Our ref: AE/2021/126552/01-L02
20028349

Date: 11 November 2021

**APPLICATION BY HIGHWAYS ENGLAND FOR AN ORDER GRANTING
DEVELOPMENT CONSENT FOR THE A47 NORTH TUDDENHAM TO EASTON
PROJECT**

**DEADLINE 4 SUBMISSION: COMMENTS ON DOCUMENT 9.12 ADDITIONAL
INFORMATION FOR THE LEAD LOCAL FLOOD AUTHORITY AND THE
ENVIRONMENT AGENCY**

Figure 2-1 Comparison of flood extents along the Oak Farm watercourse pre- and post-development during a 1 in 100 year event with a 65% allowance for climate change

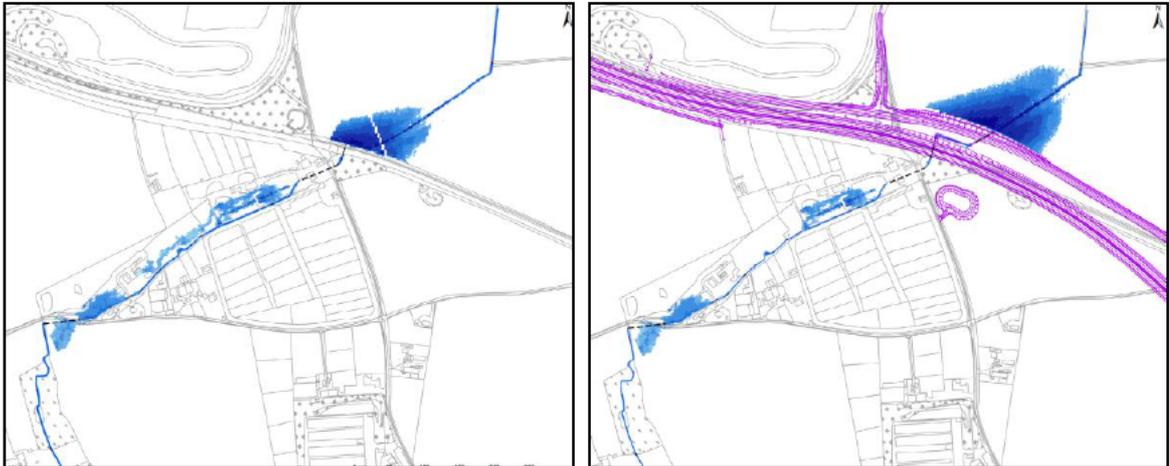
Section 2.2 of the document refers to the compensatory flood storage on the Oak Farm watercourse. Section 2.6 refers to a meeting to be had with the landowner affected by the increased flood storage upstream of the Oak Farm culvert. We have advised the Applicant that we would wish to be updated on the outcomes of that meeting, and see confirmation that the landowner is accepting of the increase in flood risk.

Figure 0.2 Hockering Baseline full flood extent

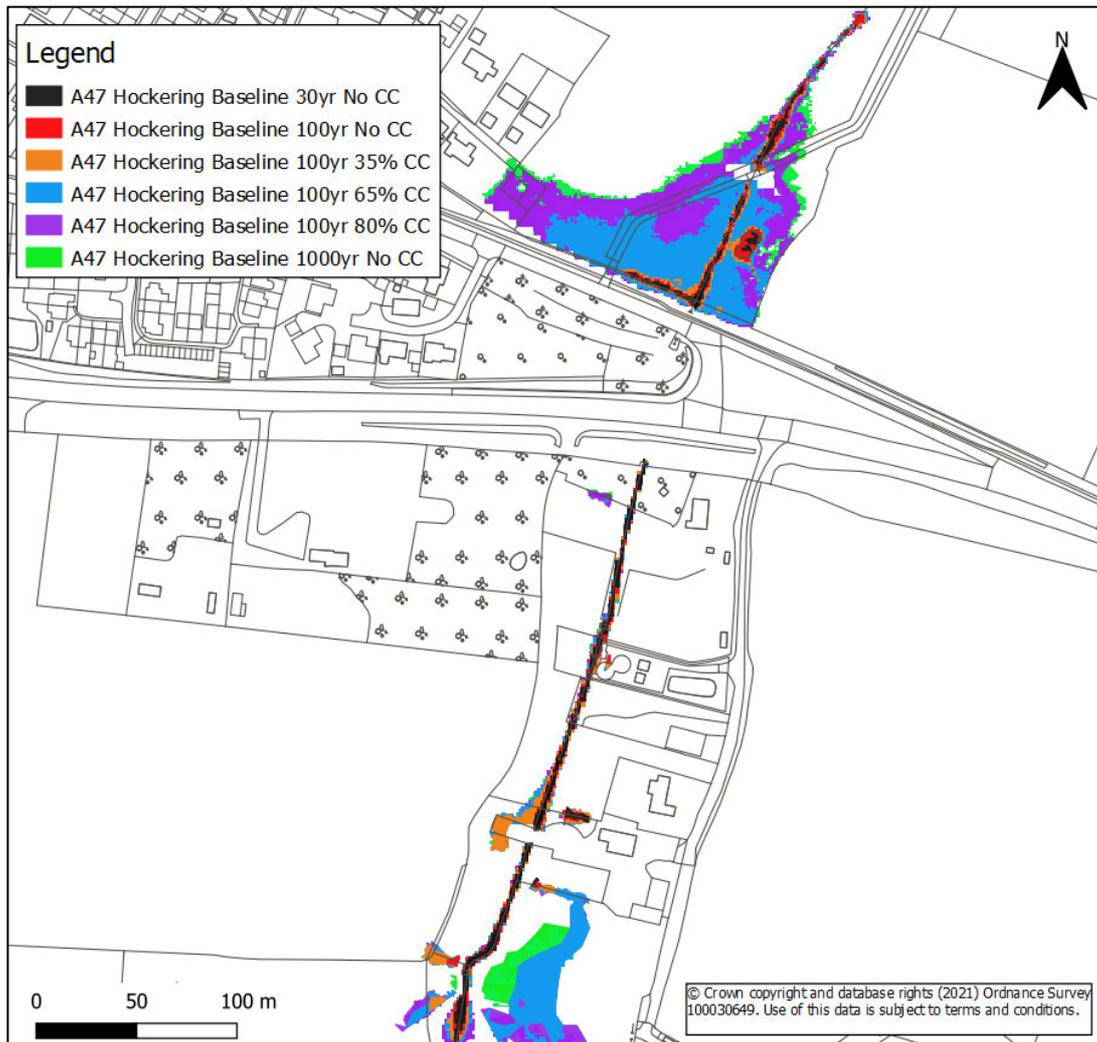
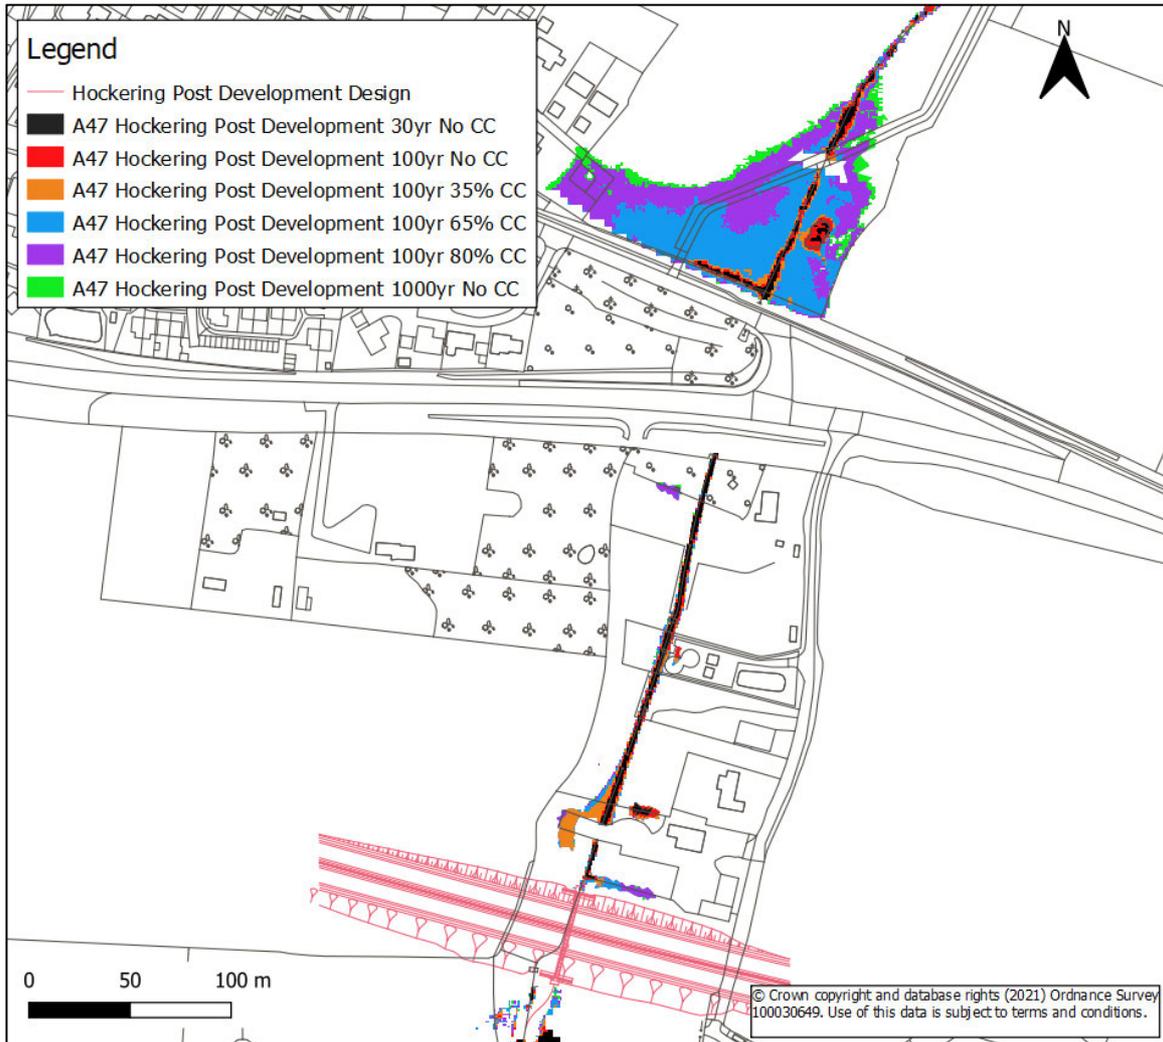
Section 2.7.2 and 4.1.1 of the document refer to new 1D-2D hydraulic flood risk modelling and an updated model report for the Hockering culvert. We will await these to be provided to us for review. Section 2.10.5 determines that 11m³ of flood storage is lost in the 1% (1 in 100) annual exceedance probability event, plus 35% allowance for climate change on an ordinary watercourse. In section 2.10.6 the Applicant has proposed that no flood compensatory storage area is provided, stating a "lack of meaningful detriment, small loss of floodplain storage and the improved confidence in the hydraulic model".

Ideally we would like to see this lost flood storage compensated for. The individual effect of not carrying out compensation works for the loss of floodplain storage may appear to be minor or insignificant, but the cumulative effect of such proposals can result in more significant impacts.

At this location there is an existing road and culvert approximately 200 metres upstream, and the project would result in a new road and culvert immediately downstream. These constrictions on fluvial flows may limit the possibility of any adverse cumulative effects arising from not providing compensatory storage for the 11m³ lost at this location.

We have requested that the Applicant provides further information on the reasons for not providing compensatory storage, and further detail on what happens as a result of 11m³ of flood storage being lost. For example, is that volume retained within the application site boundary with the new culvert downstream regulating the flow rates? Or if not, does the 11m³ of lost flood storage result in any offsite impacts and where are those impacts?
